Our ref: 25_33194_P

Site Location: Land off High Road Moulton

Summary of Proposal: Change of Use to fishing and wildlife holiday lodges, erection of 5 modular holiday lodges with associated landscaping, planting and parking - Approved under H13-0683-20. Modification to Condition 2 to allow amendments to previously approved plans

PROPOSED SITE LAYOUT

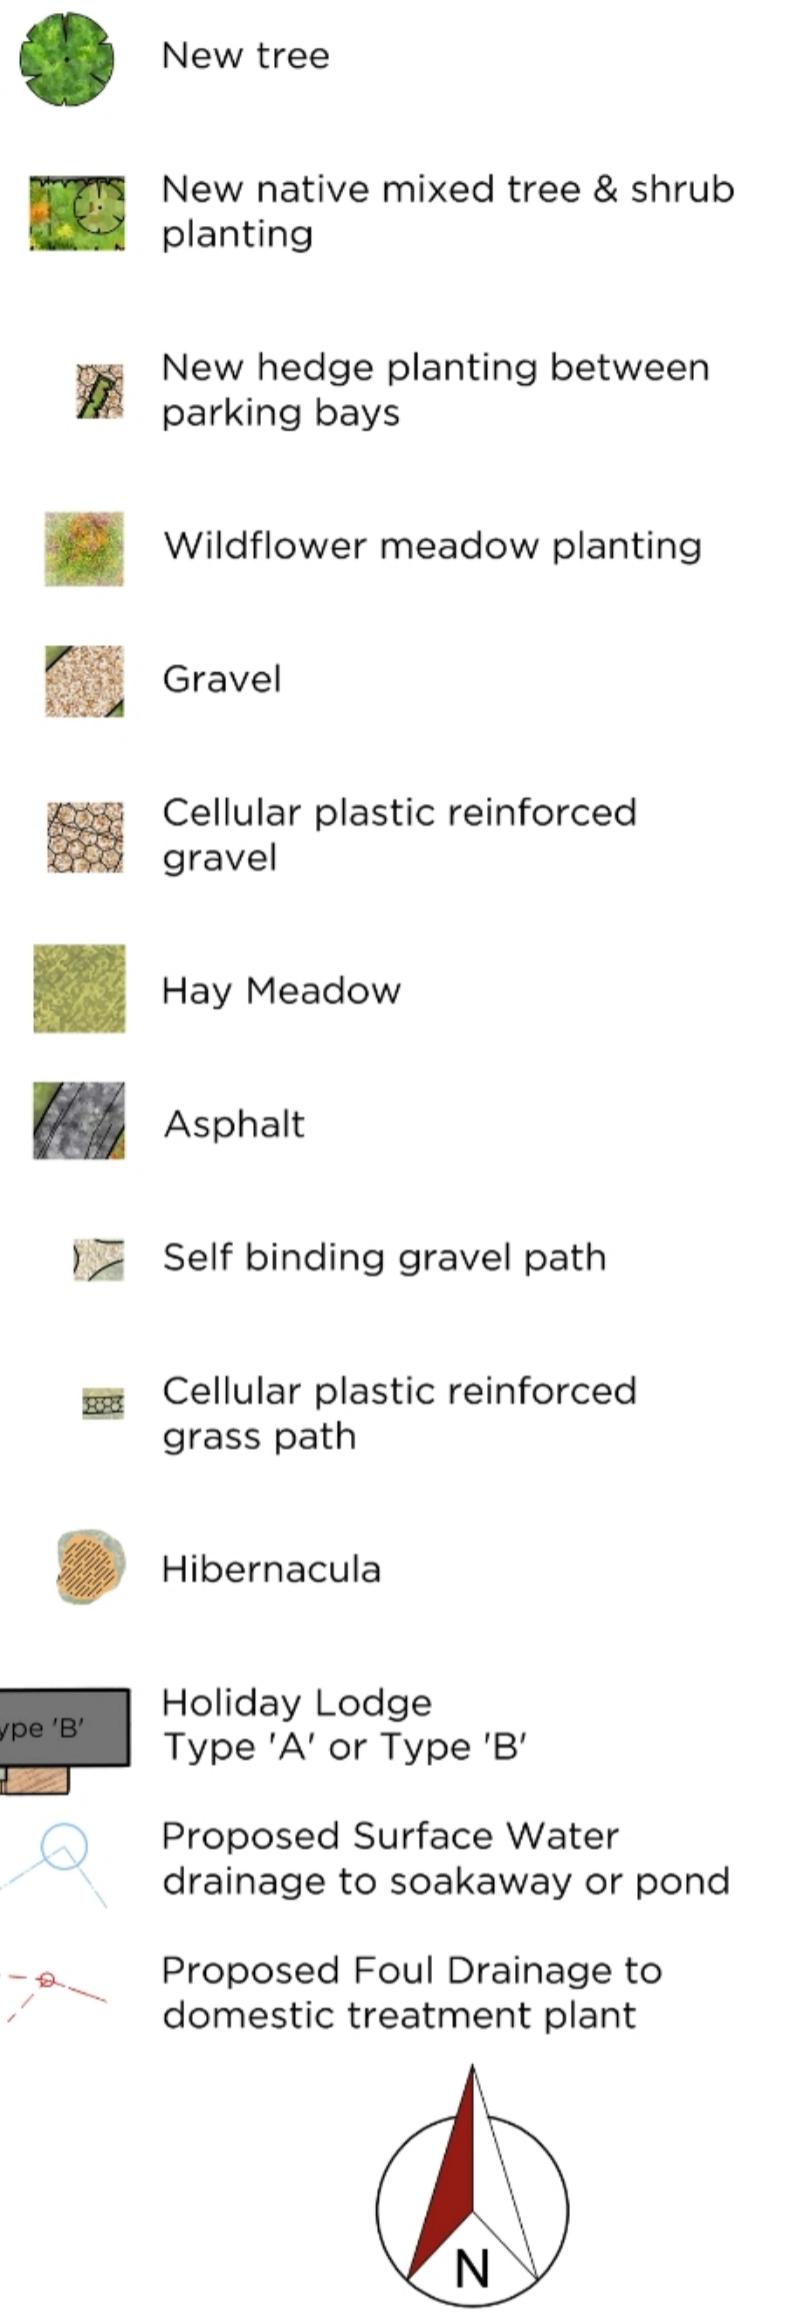
I note the presence of a watercourse which is not maintained by the Board (a riparian watercourse) within the southern site boundary and that works are proposed to alter this watercourse via the widening of the existing the access by 5 metres, as shown in drawing 'Proposed Site Layout 005 P01 Rev A (Seven 22 Architecture Ltd, 31/08/2025). To enable this proposal consent is required under Section 23 of the Land Drainage Act 1991 (and byelaw 4) and I recommend that the applicant contacts this office to make an application for this consent at their earliest convenience.

LAND OFF A151, MOULTON, LINCOLNSHIRE
PROPOSED SOAKAWAY ARRANGEMENT

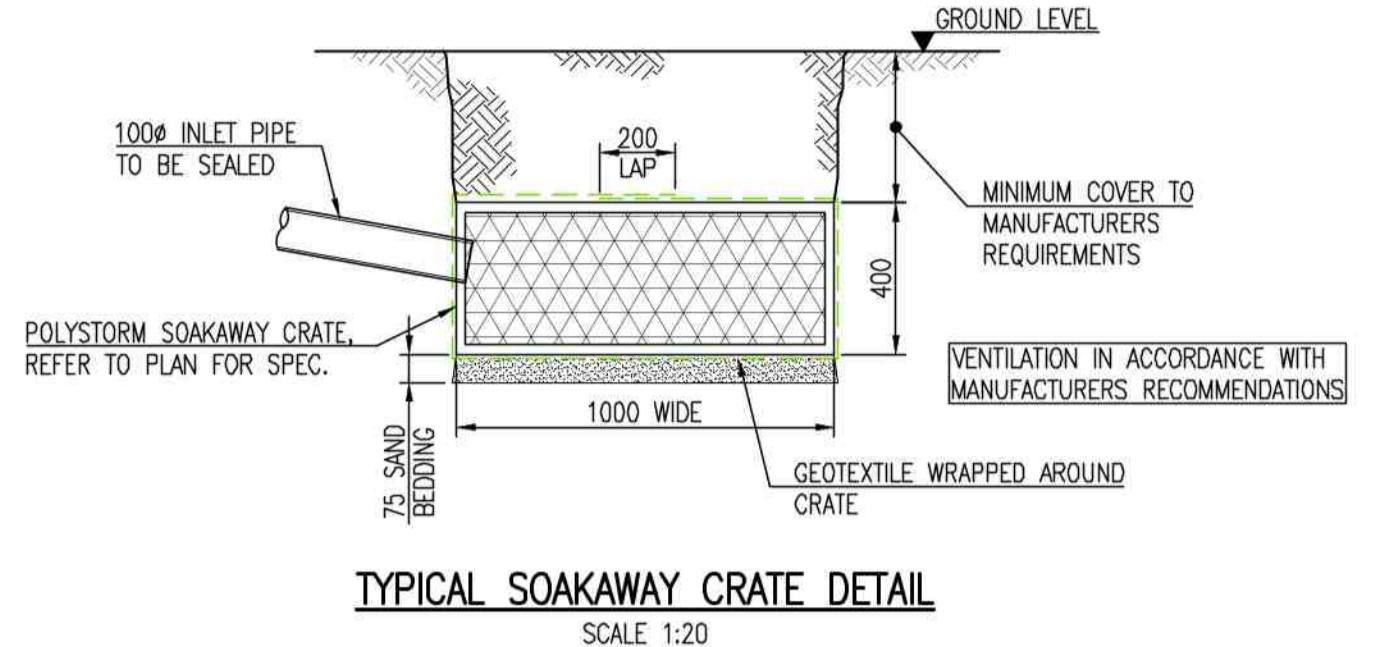
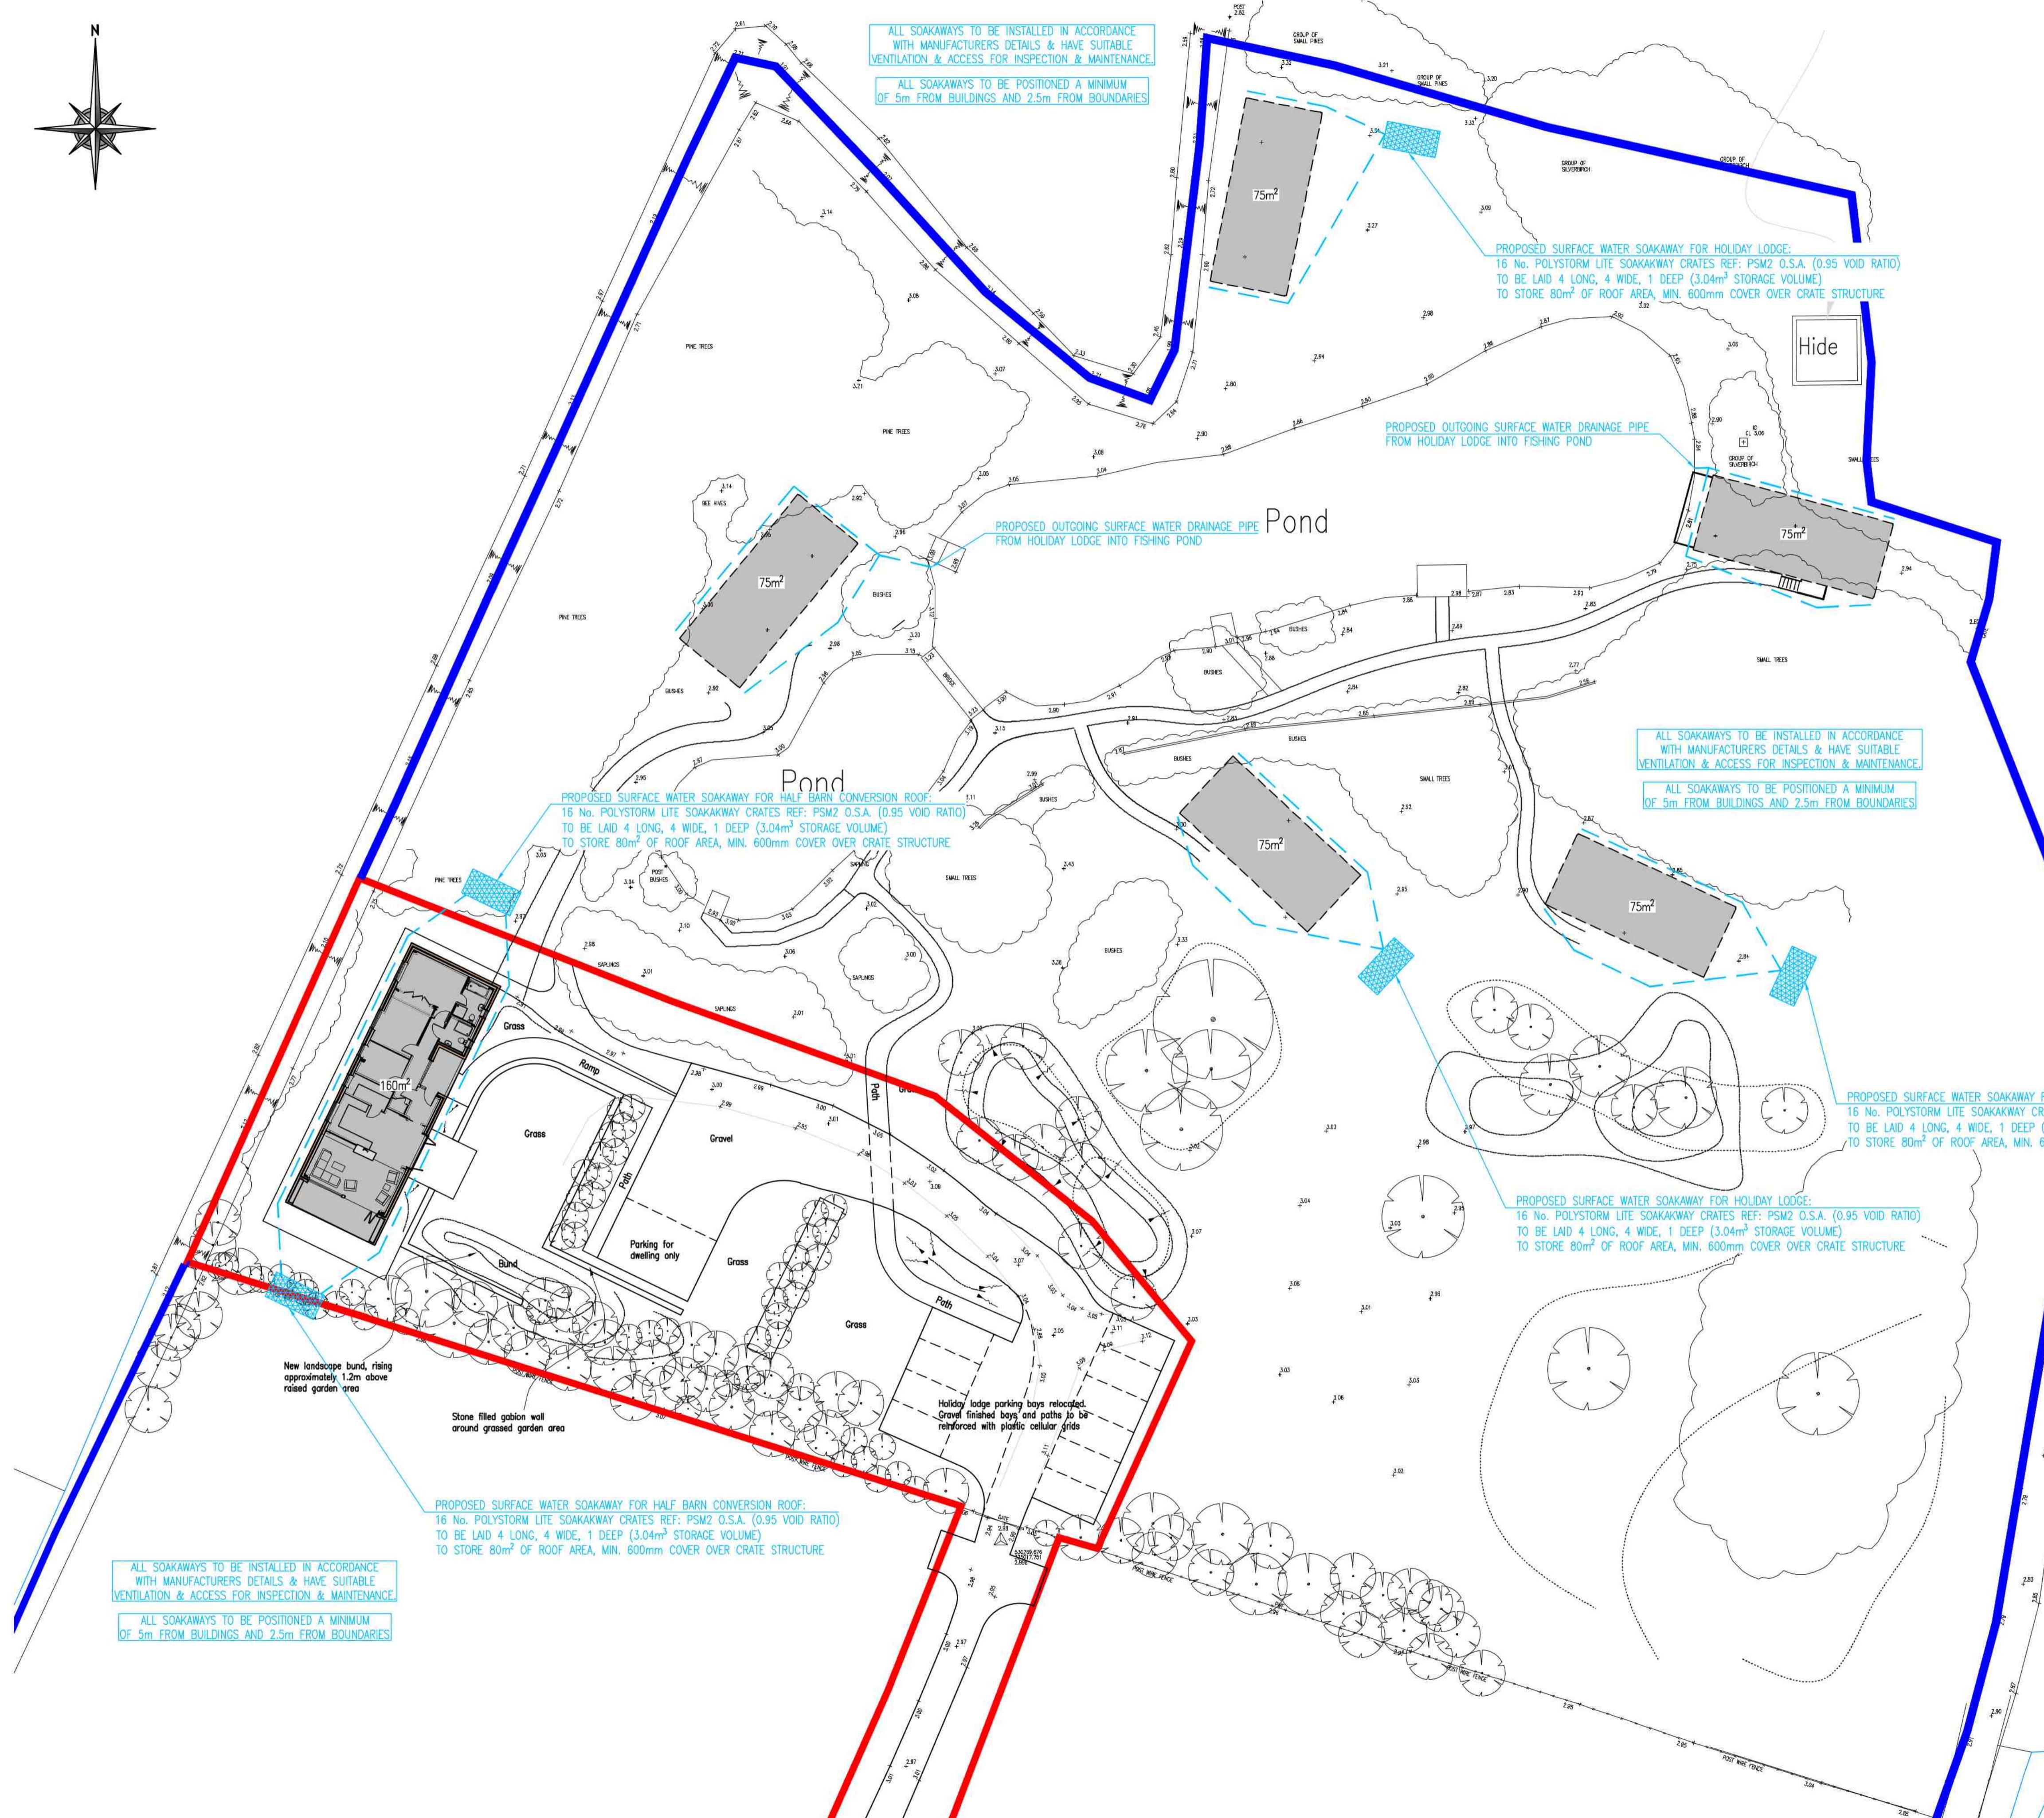
I am pleased to see that initial testing shows that a drainage strategy reliant on infiltration is likely to be achievable on the proposed development, as evidenced within 'Proposed Ground Investigation Report & Soakaway Surface Water Drainage Scheme Calculations SW25-389-REP-01' (05/01/2026 Shield Wilson).
